Diane Sarkies - NWRL EIS2 objection - Impacts on Cheltenham Oval from Service facility

From: "Yates, Matthew" <Matthew.Yates@lendlease.com>
To: "plan_comment@planning.nsw.gov.au" <plan_comment@planning.nsw.gov.au>
Date: 20/11/2012 9:22 AM
Subject: NWRL EIS2 objection - Impacts on Cheltenham Oval from Service facility

Re: North West Rail Link EIS2
 Application number: SSI-5414

Figure 2 Cheltenham service facility – heavy vehicle routes (EIS 2 works)

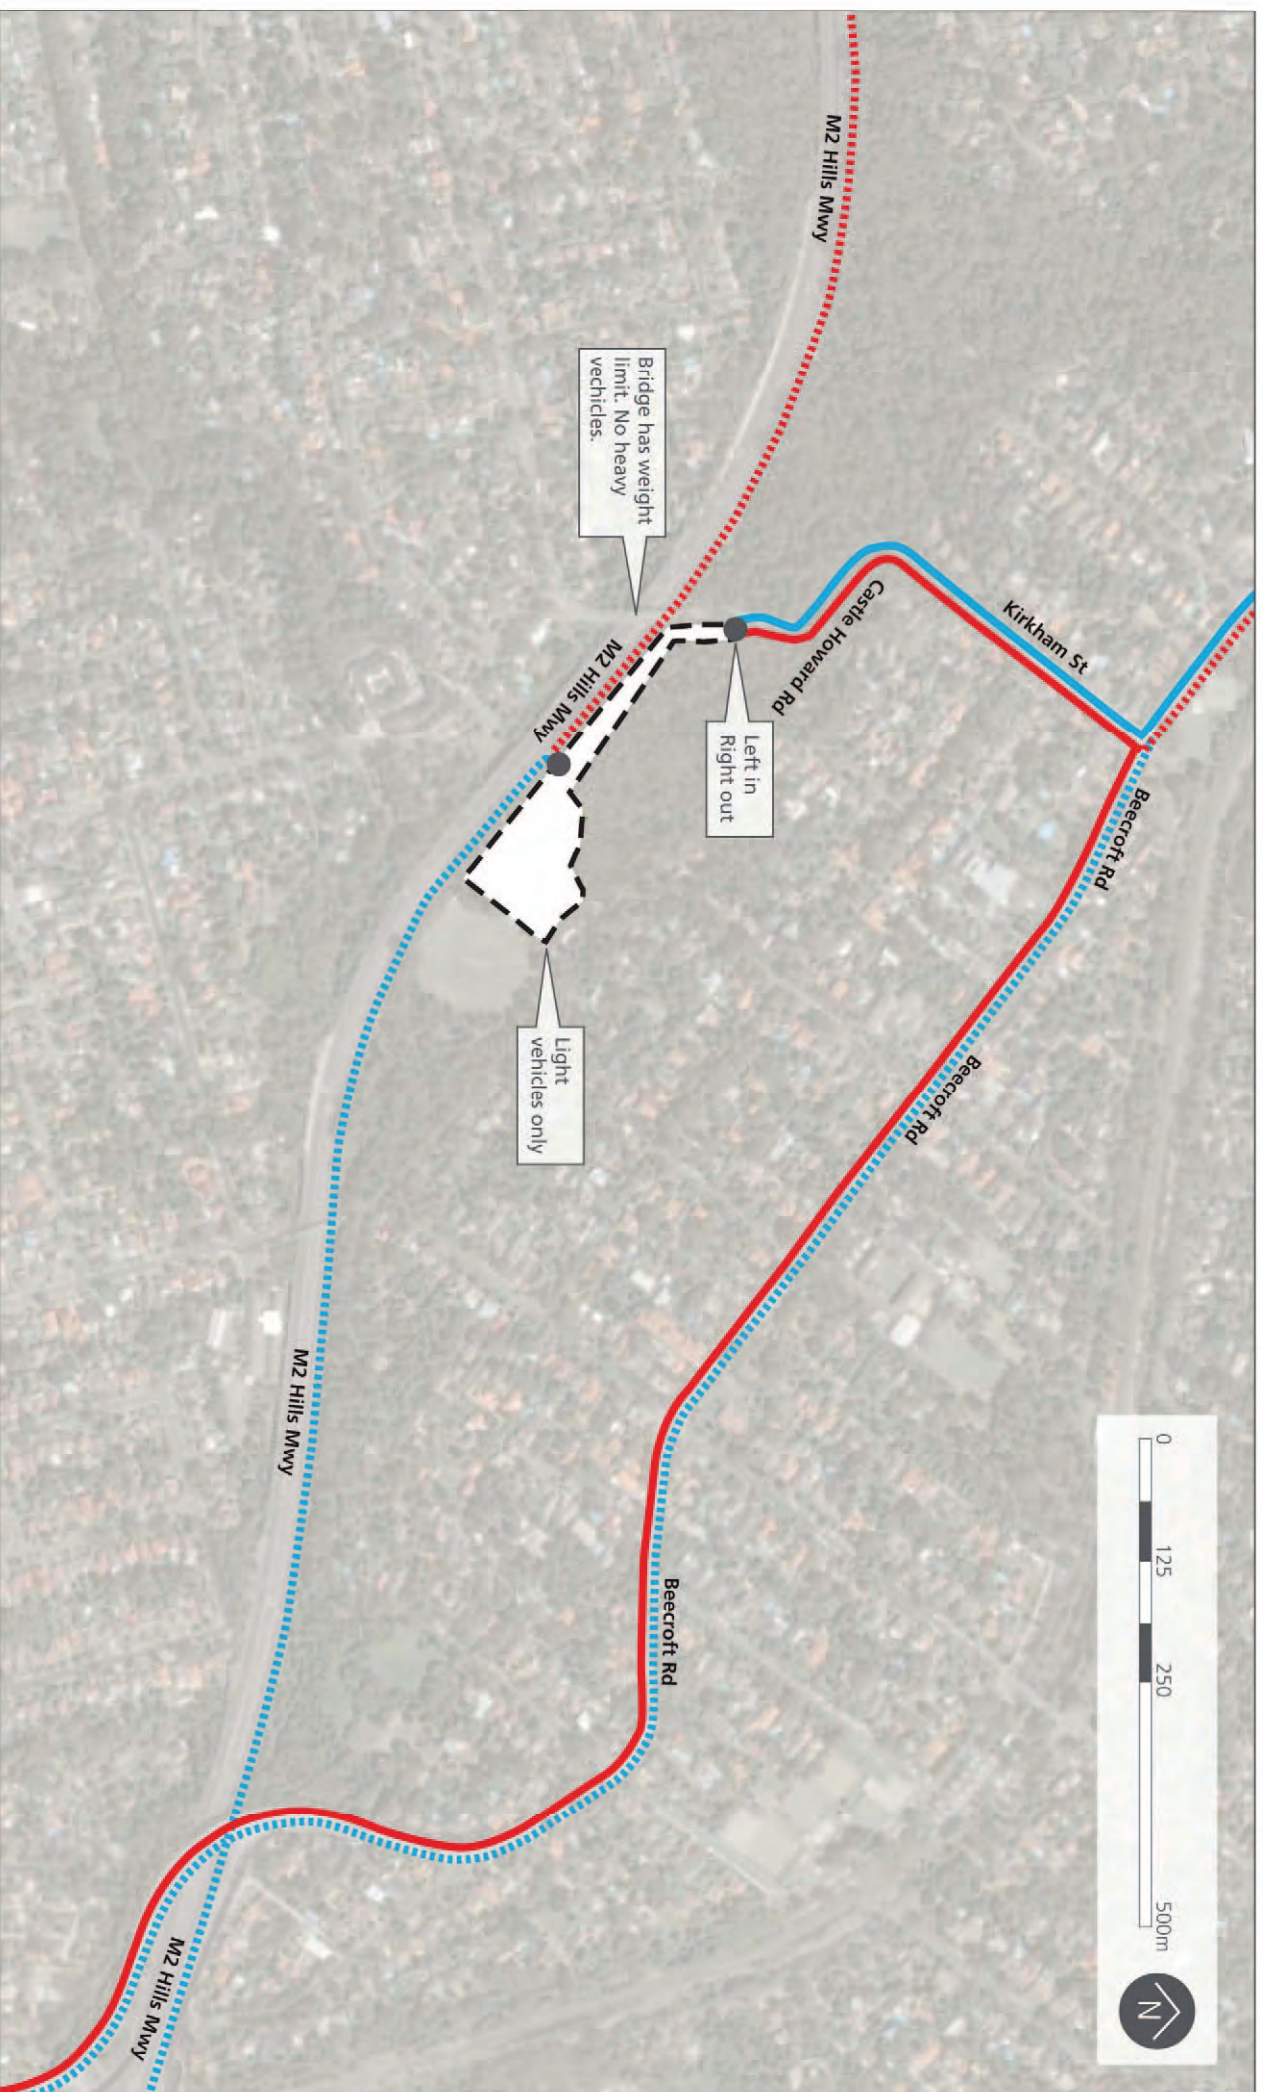
The Services Facility proposal is very thin on detail but patently gives nothing back except the status quo. The Netball Courts are (reluctantly) replaced, the very limited parking is (barely) replaced, the amenities are (reluctantly) replaced with "modern" (but smaller?) facilities (maybe). Castle Howard Road will need to be "improved" to allow truck access resulting in the removal of some large trees which for many years the road has avoided.

- Complete Castle Howard Rd. through to Lyne Rd. to give two-way access to Cheltenham Oval.
- Develop the stub of Murray Rd. (off Castle Howard Rd.) for the Services Facility or for additional car-parking for the Oval.
- Resume house(s) on Castle Howard Rd. adjacent the Oval to allow Services Facility, amenities and parking
